Your Ref: OWPC16094
Our Ref: FG/162/17/PL 10-10-2017
Please ask for:
Mrs A Gardner

Town & Country Planning Act 1990 (as amended)
Town and Country Planning (Development Management Procedure) (England) Order 2015

Demolition of existing detached garage & erection of 1 No. dwelling.
1 Upper West Drive Ferring

EXISTING SITE PLAN 1:100

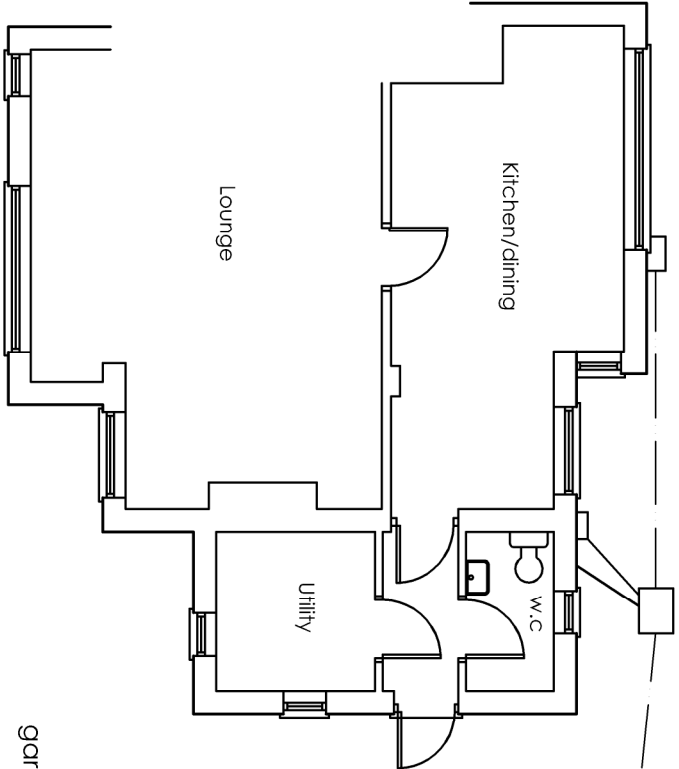
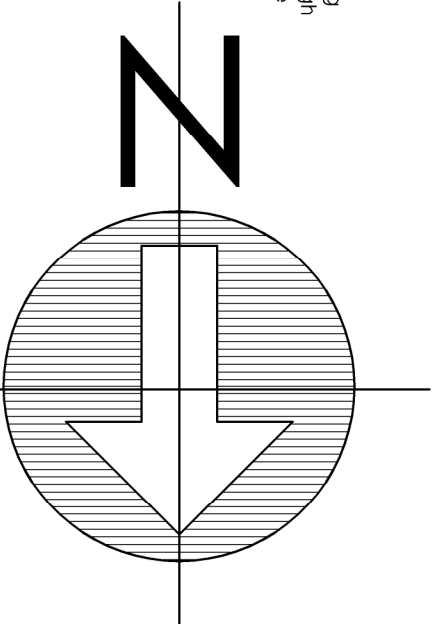
- 3. The development would compromise the protection of the large Sycamore (TPO) which is such an asset to the street scene. Inevitably, the owners of the bungalow would, sooner or later, complain that the tree was damaging their drains or foundations, or risking boughs falling on the building or simply excluding too much light.*

PROPOSED GROUND FLOOR PLAN 1:100

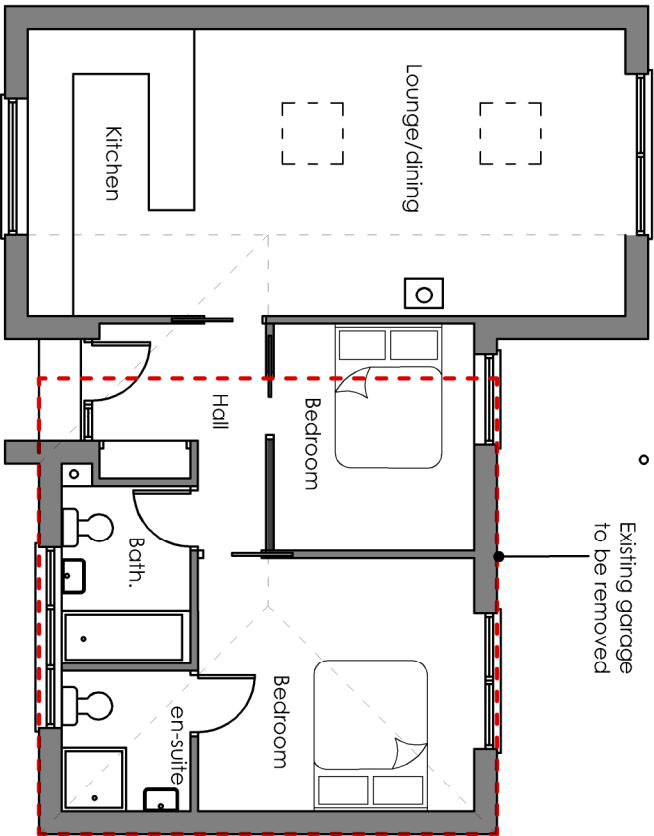
- 1. This would be an overdevelopment of a site since at least 1932 as a garage for No.1 Upper West Drive. It would be a cramped and unneighbourly development, leaving only 1 metre gap between the south wall of the proposed bungalow and the fence, and only the same distance between the fence and the north wall of No.1 Upper West Drive.*
